Our ref: Novus Build-to-Rent, Victoria Avenue, Chatswood (SSD-63324208)

25 September 2025

Subject: Request for Additional Information

DA 099

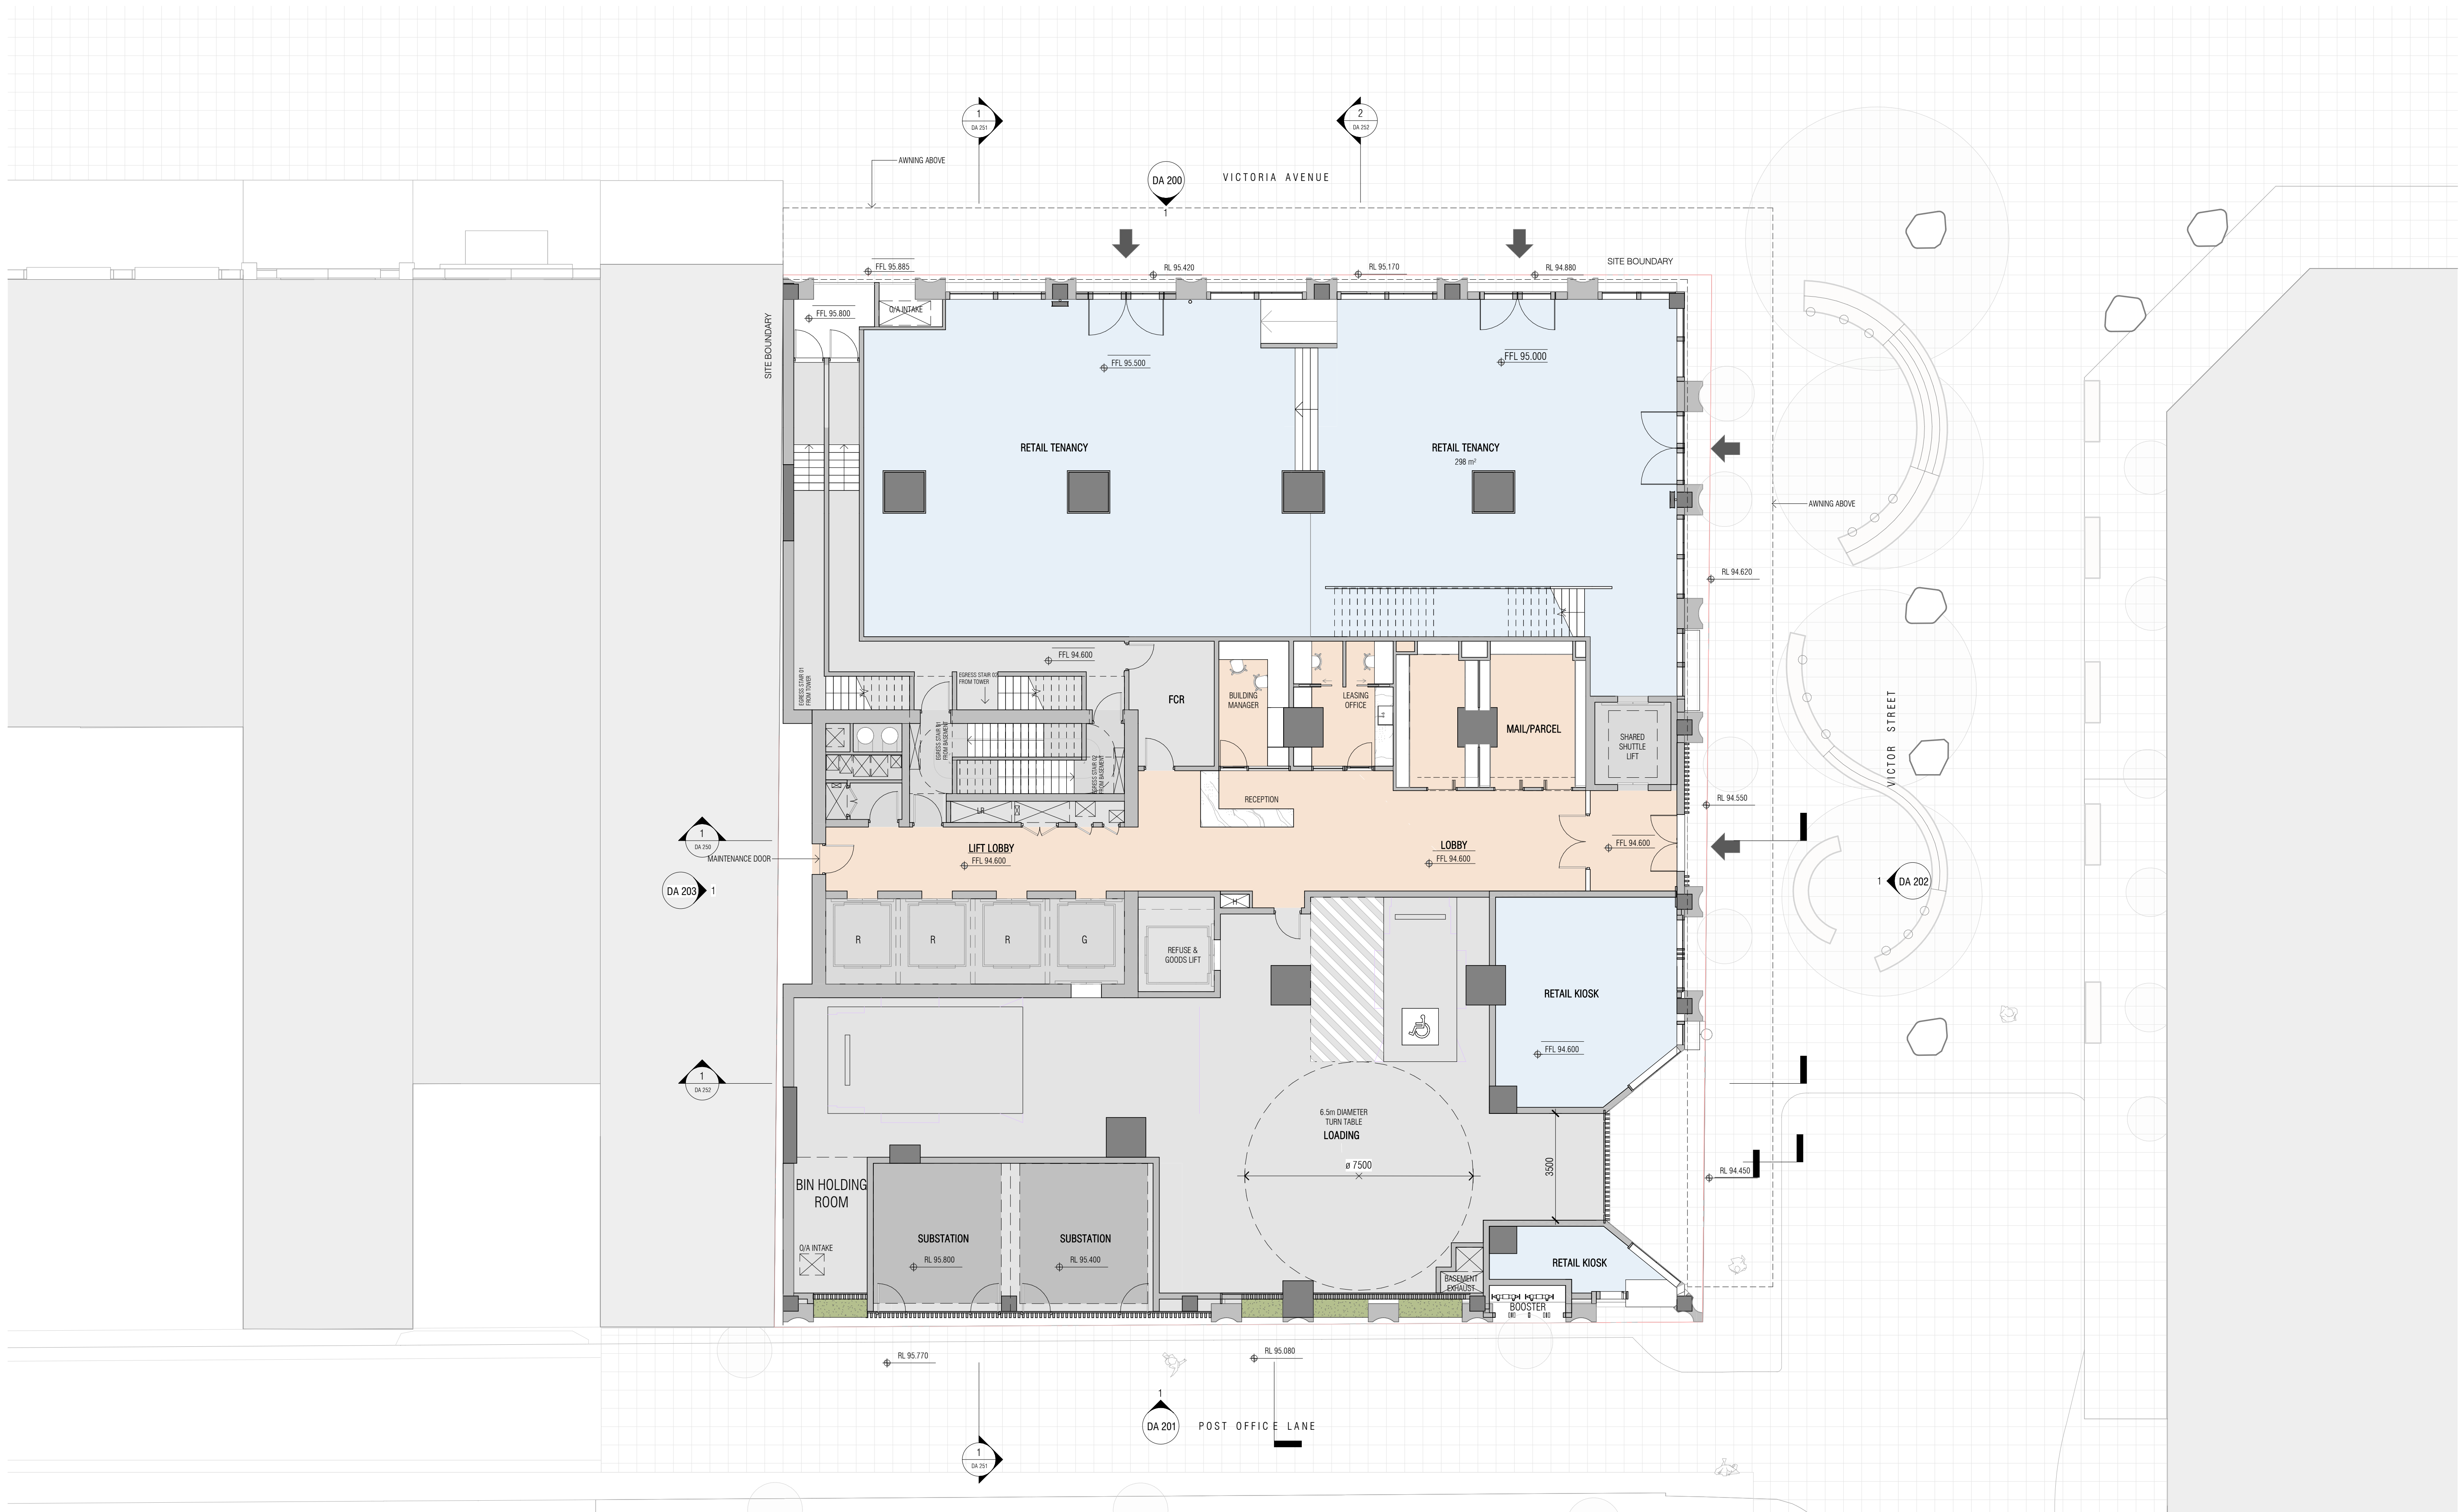
3. The WLEP 2012 maps Post Office Lane as an 'active street frontage', where Section 6.7 of the WLEP promotes uses that attract pedestrian traffic. The Department requests that the arrangement of the ground floor be reconsidered / refined to increase the amount of active frontage on Post Office Lane, such as relocating the bin store near the western boundary and providing space for a small retail tenancy (café or kiosk similar in size to that provided on the corner of Post Office Lane / Victor Road).

DRAWING TITLE
NORTH ELEVATION - TOWER

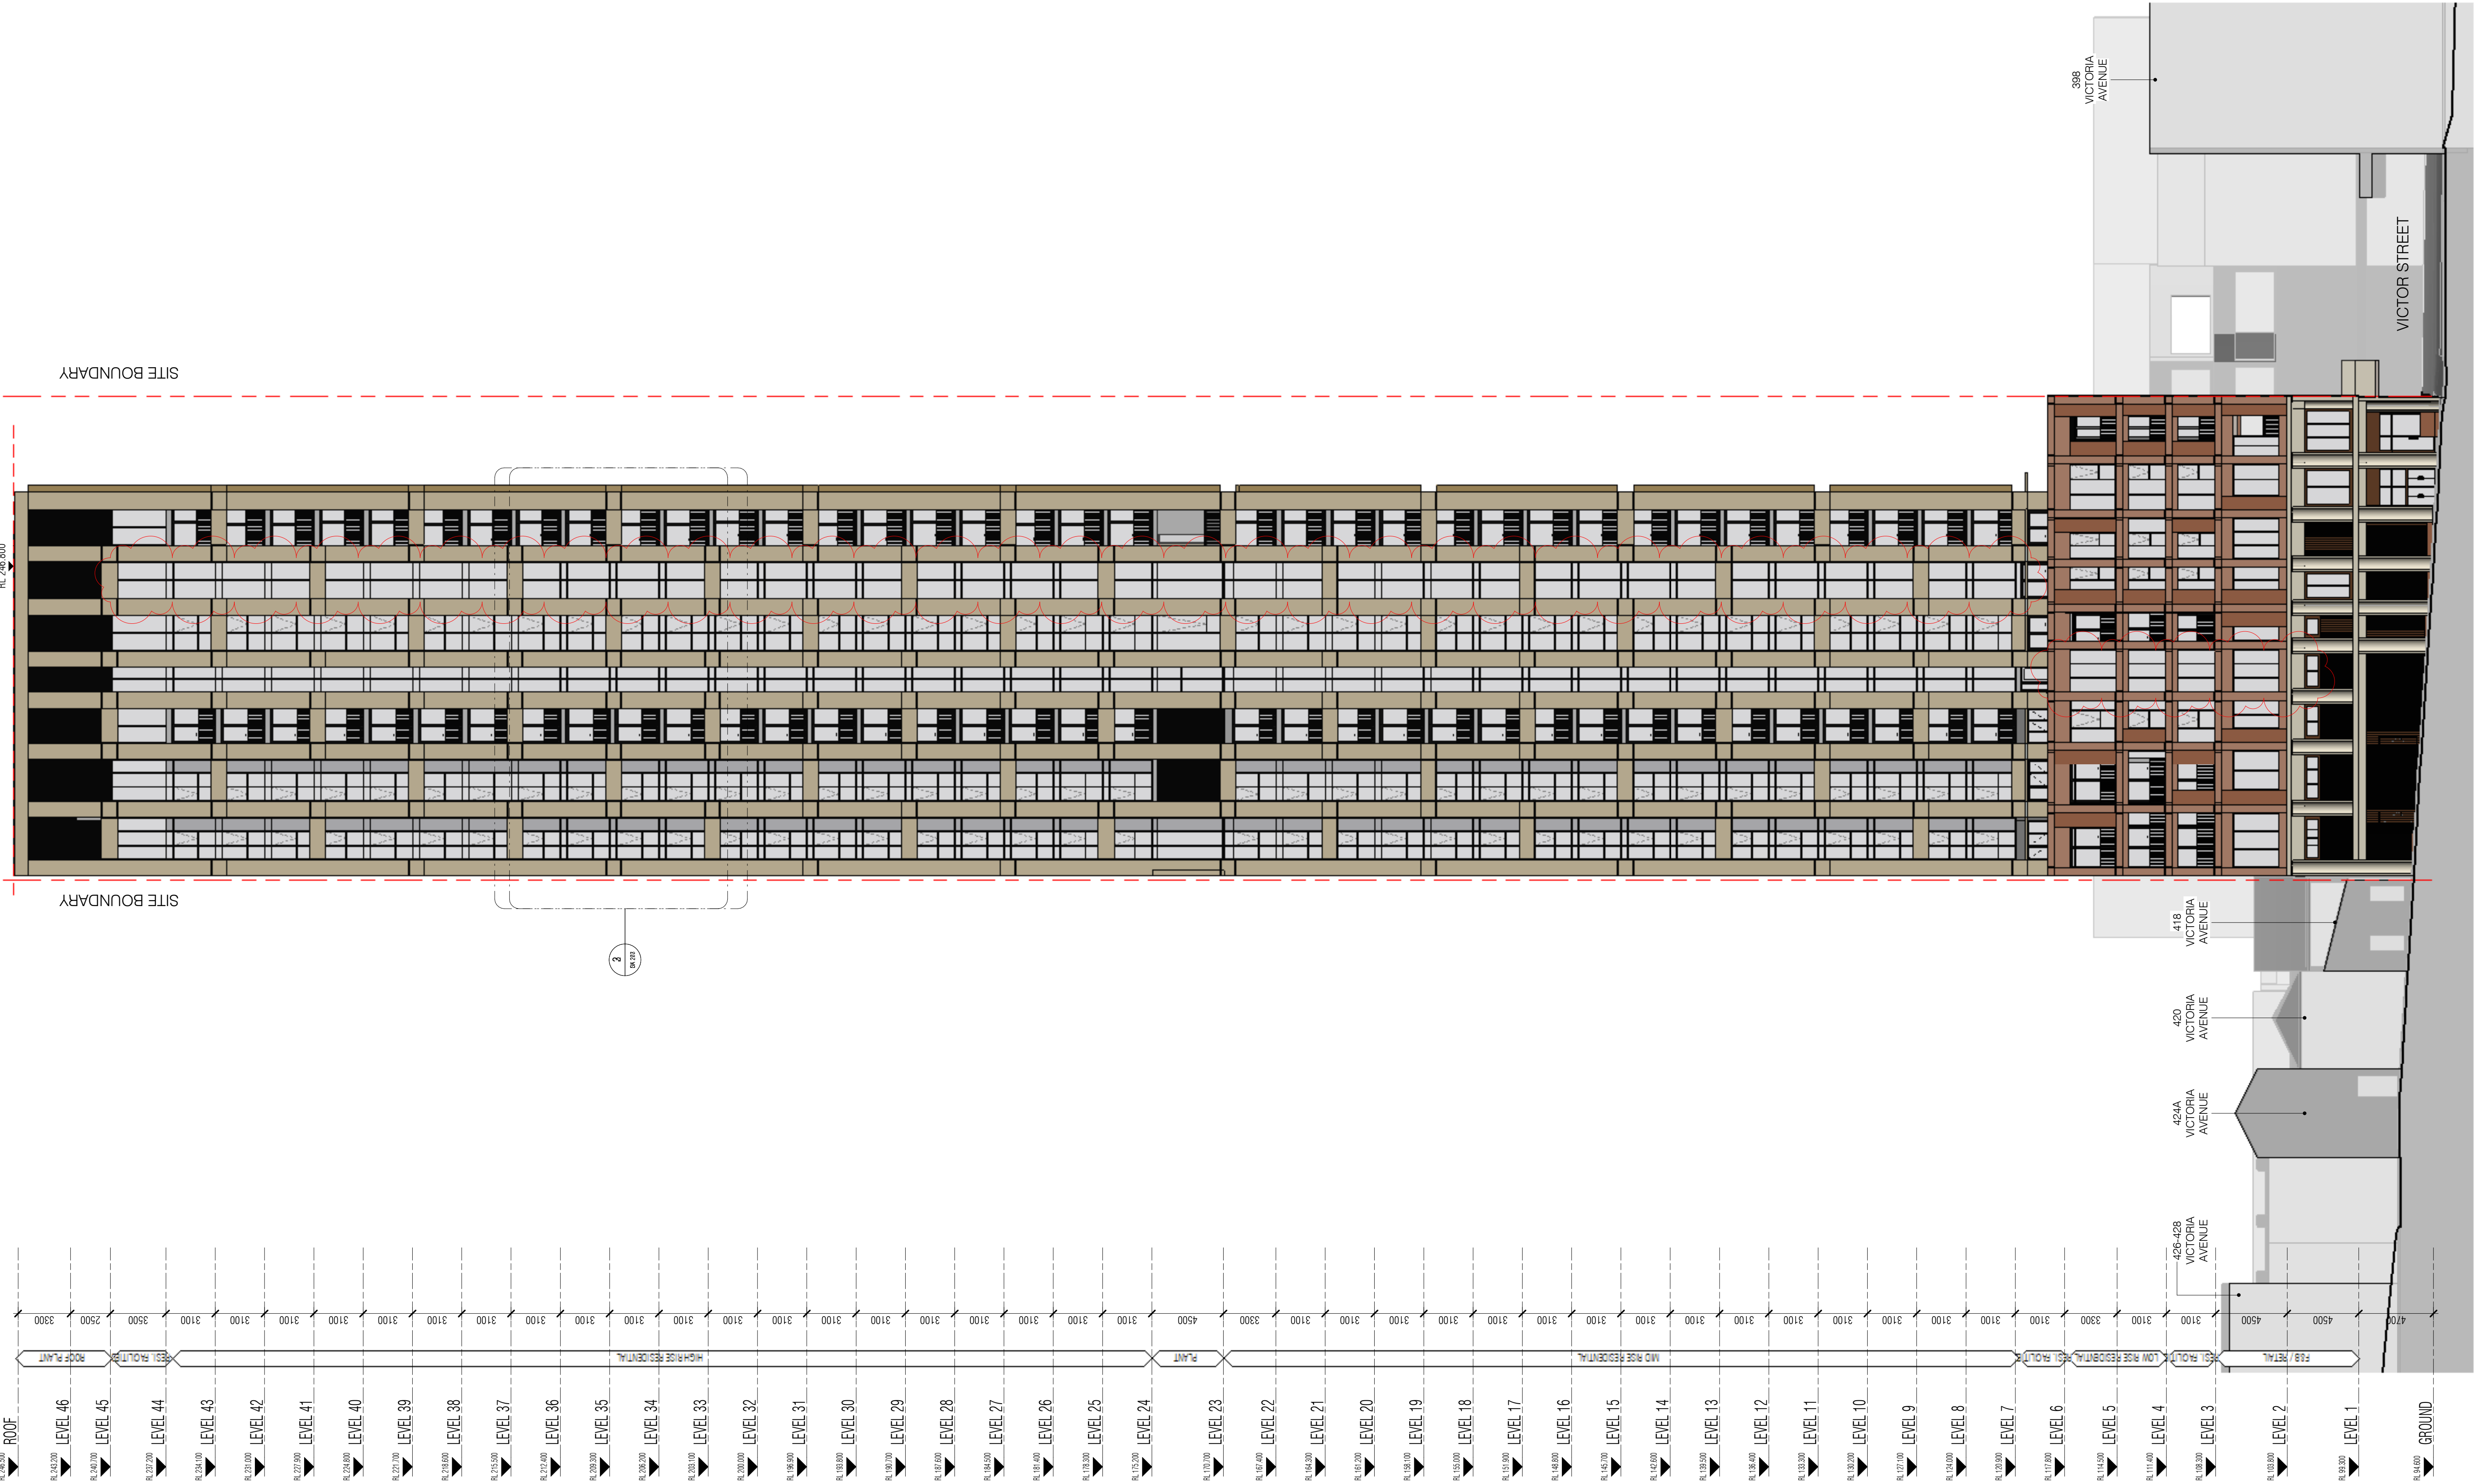
1. The proposal appears to provide building elements, such as balustrades and awnings to the communal podium area and the tower's façade articulation, extending into the area mapped in the *Willoughby Local Environmental Plan 2012* (WLEP) with a 7m maximum height limit. Please provide further justification on the compliance of these building elements within the height control and, if required, submit a revised Clause 4.6 variation request.

DRAWING TITLE
SOUTH ELEVATION - TOWER

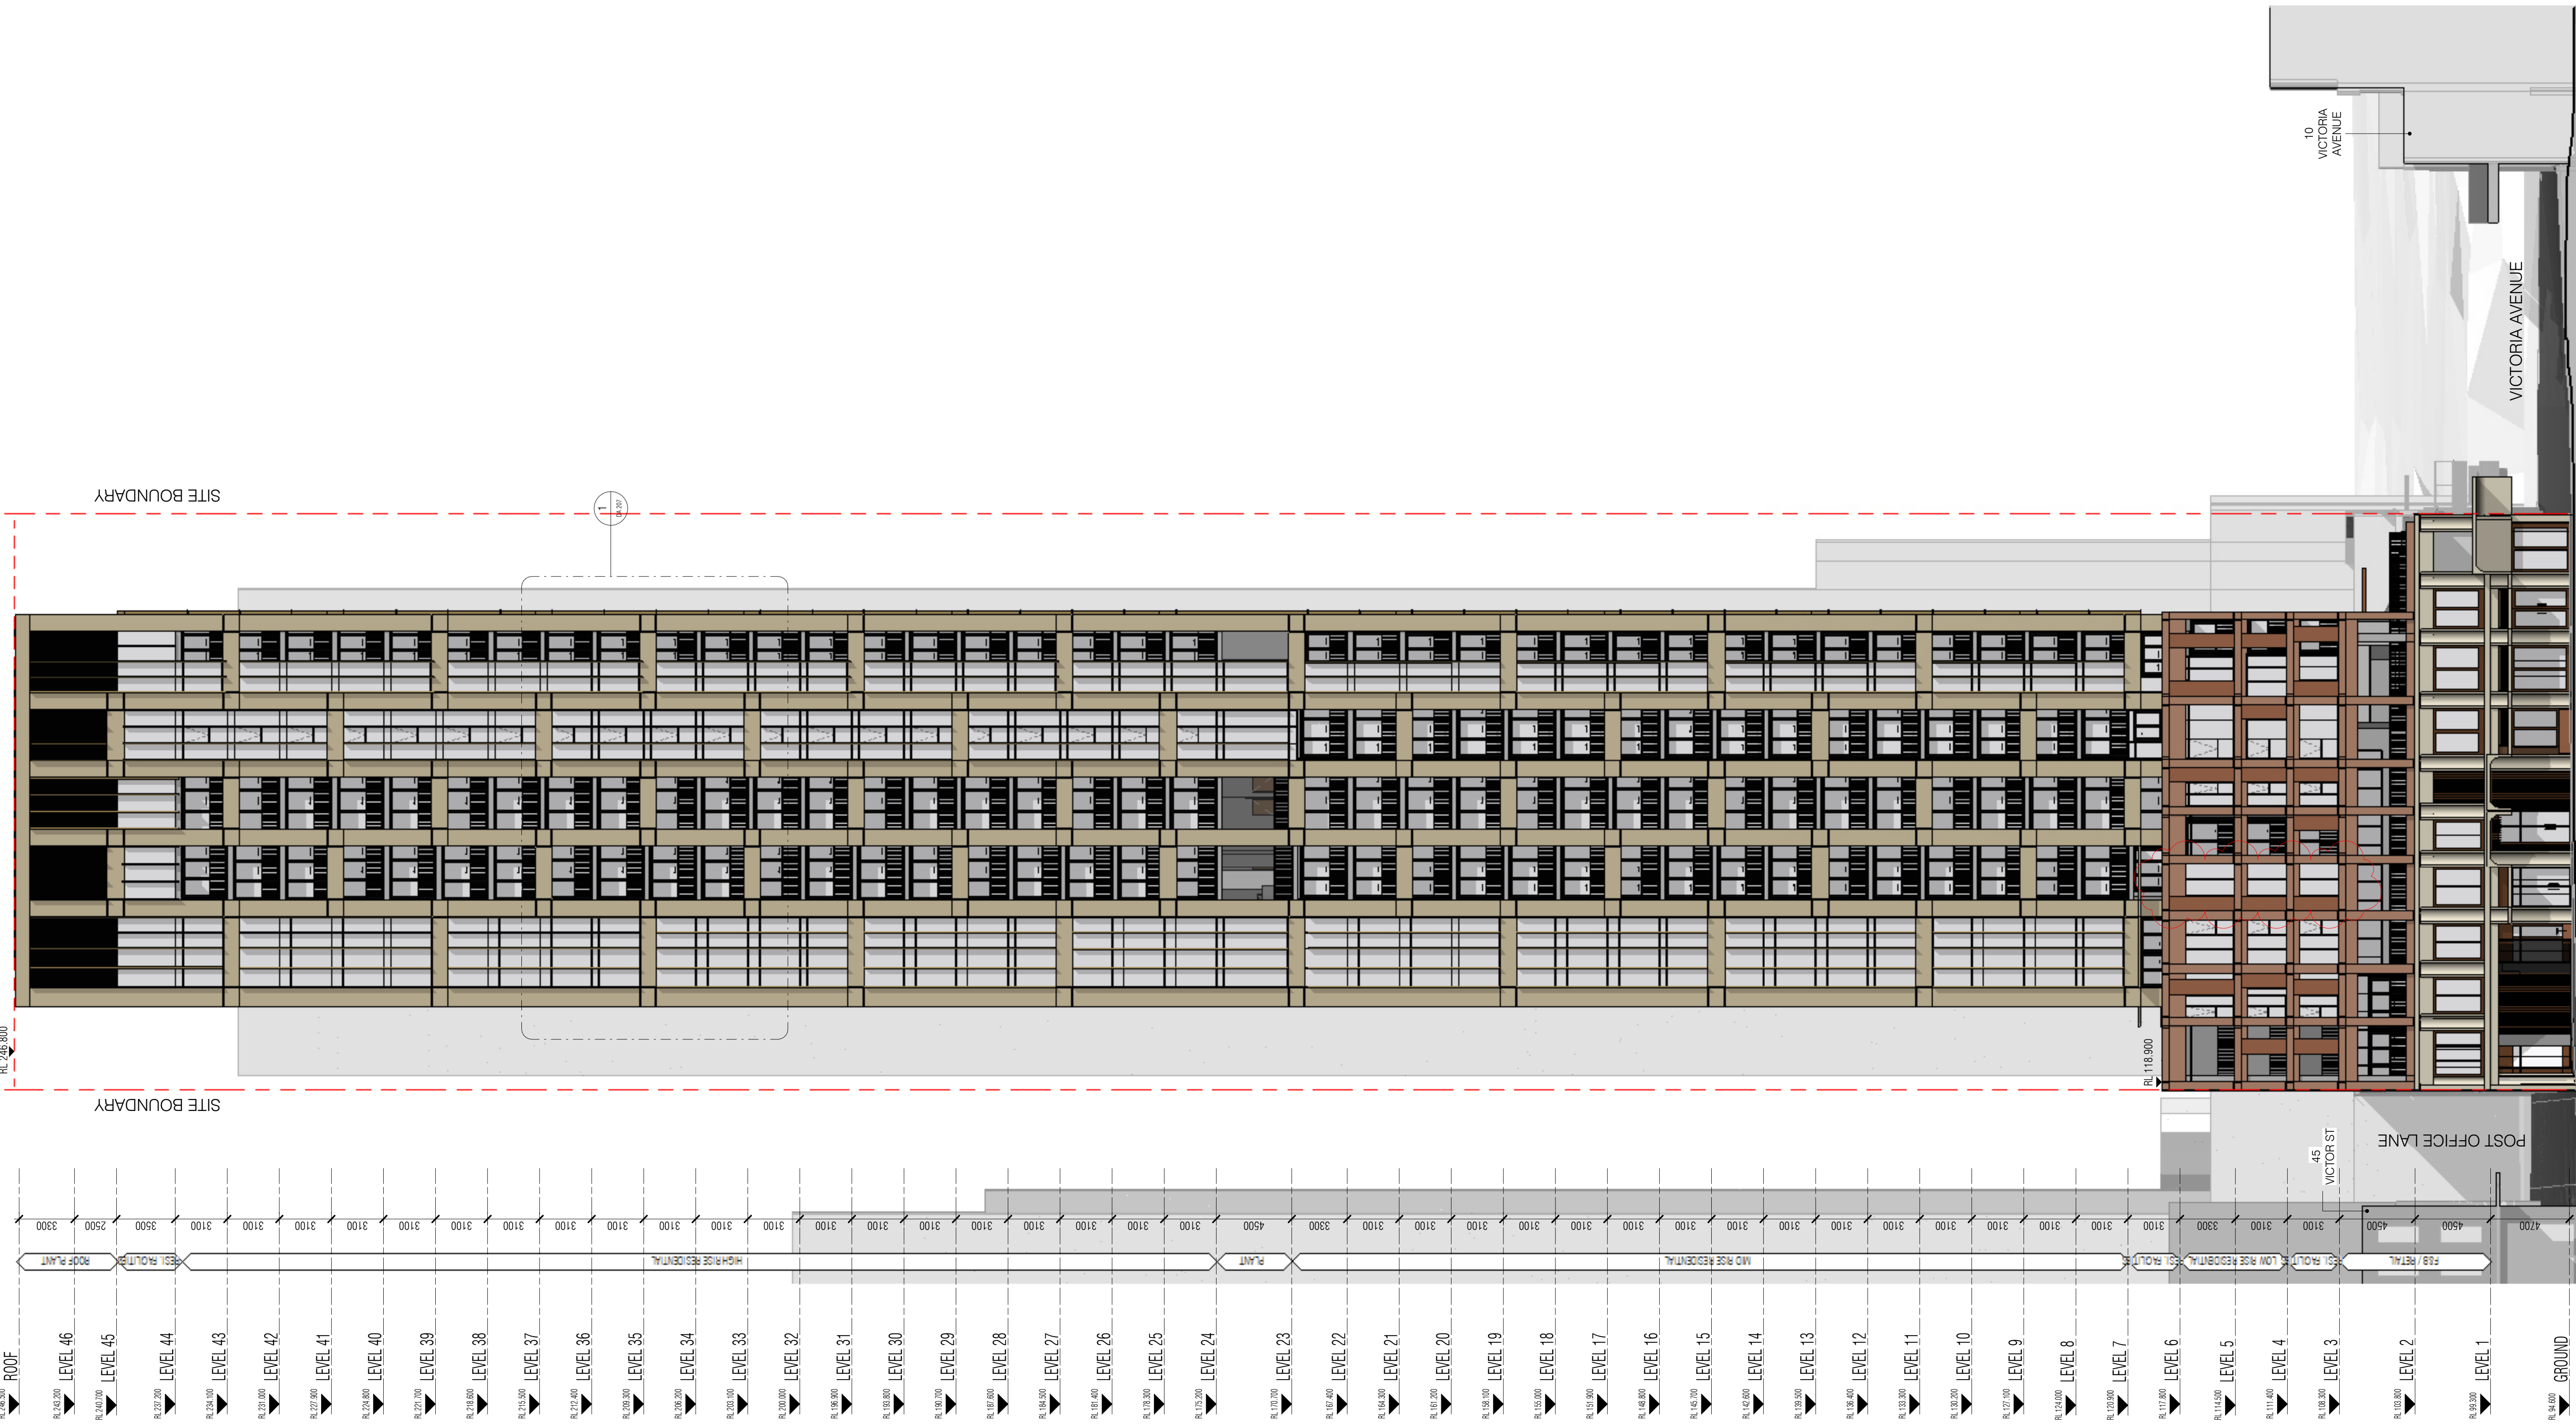
of privacy impacts to the anticipated future development directly south of Post Office Lane (45 Victor Street), including proposals to mitigate potential privacy impacts to offset the reduction to the recommended setback in the Apartment Design Guide (ADG).
